Final Drainage Report

**Double Spur Ranch  
Minor Subdivision  
12420 Meridian Rd,  
Colorado Springs, CO 80908**

← Unresolved from  
review 1: Add PCD  
File No. MS-235

Prepared: July 11th, 2022

DOUBLE SPUR RANCH MINOR SUBDIVISION
12420 MERIDIAN ROAD
DRAINAGE MAP

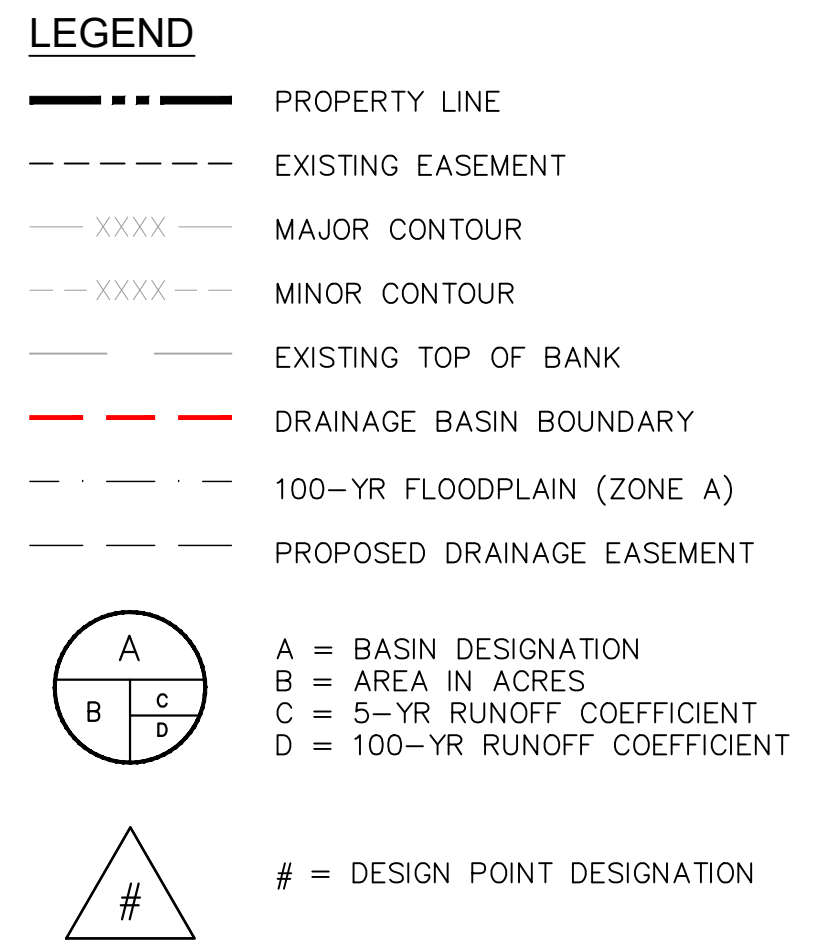
Unresolved from review 1: Provide a proposed conditions narrative. Include proposed impervious amounts with the development and how much runoff increase will result.

Unresolved from review 1: Impervious areas for the proposed lot have to be accounted for now. See previous comment about including a proposed conditions narrative.

DOUBLE SPUR RANCH MINOR SUBDIVISION
12420 MERIDIAN ROAD
DRAINAGE MAP

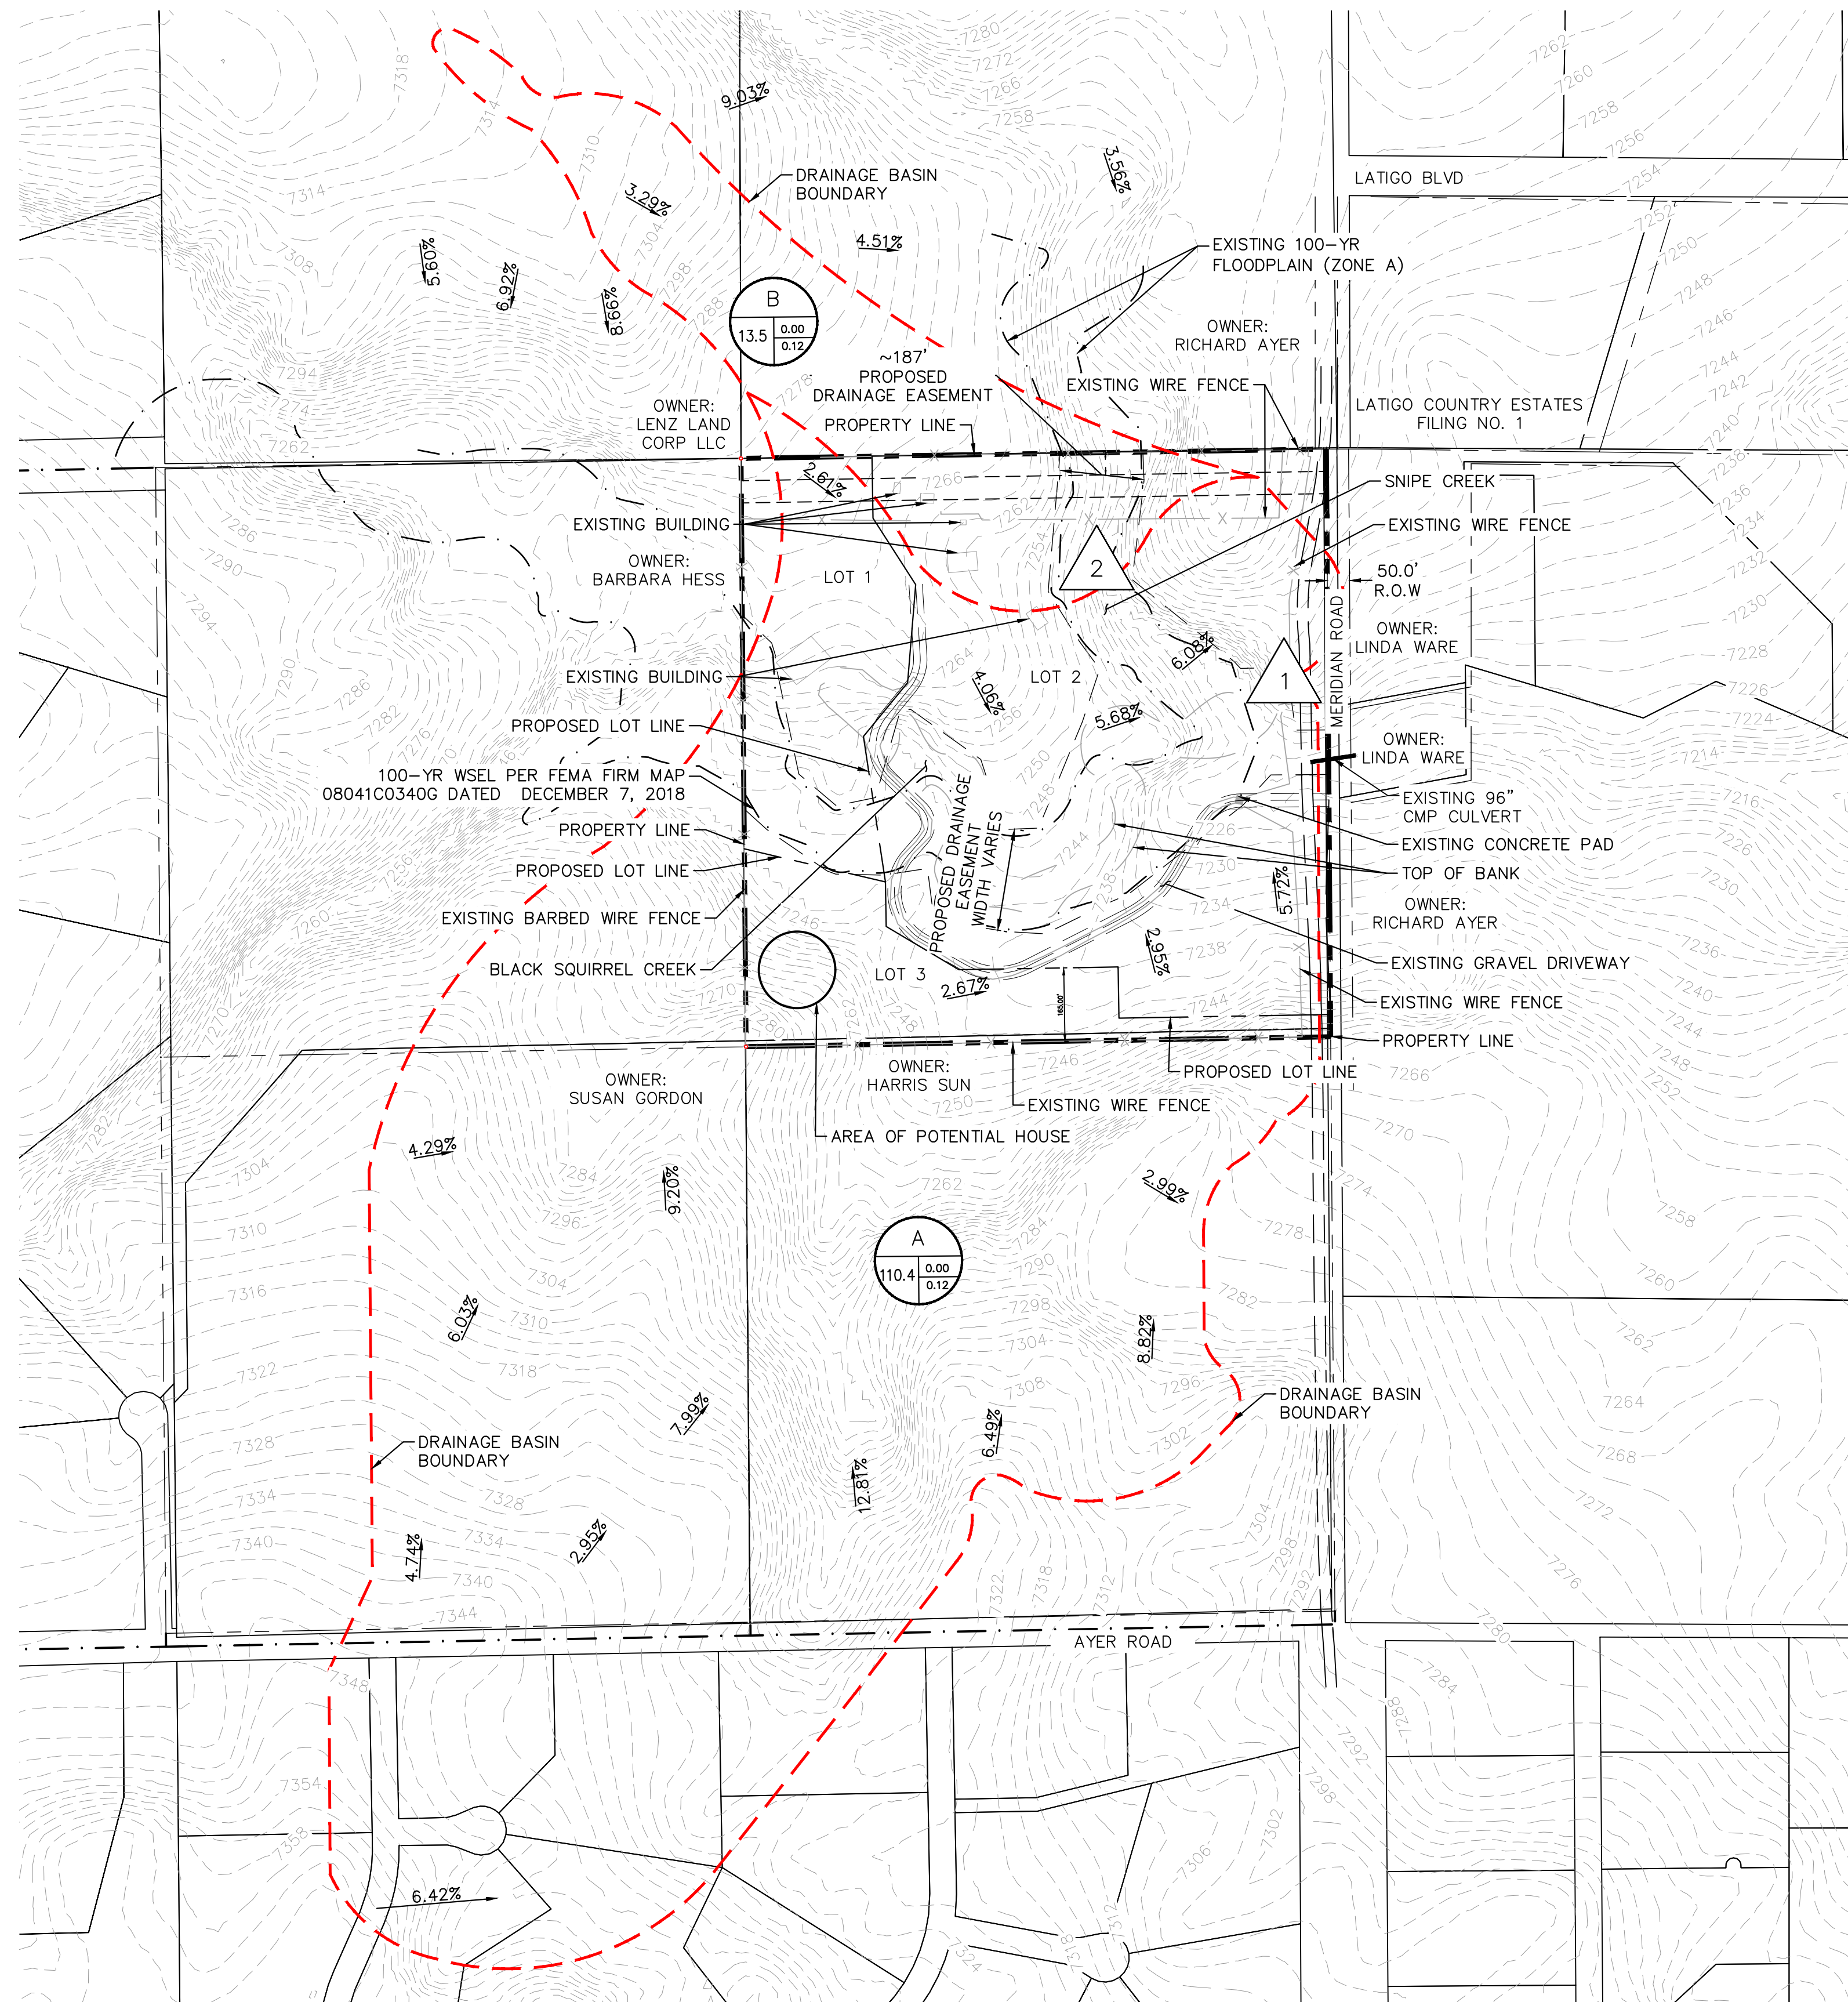
Unresolved from review 1: Revise to add to the report that houses have to be 2 feet above the easement line and if the drainage easement wants to be adjusted in the future, applicant will have to come in a process an application to adjust easement to available FEMA BFEs.
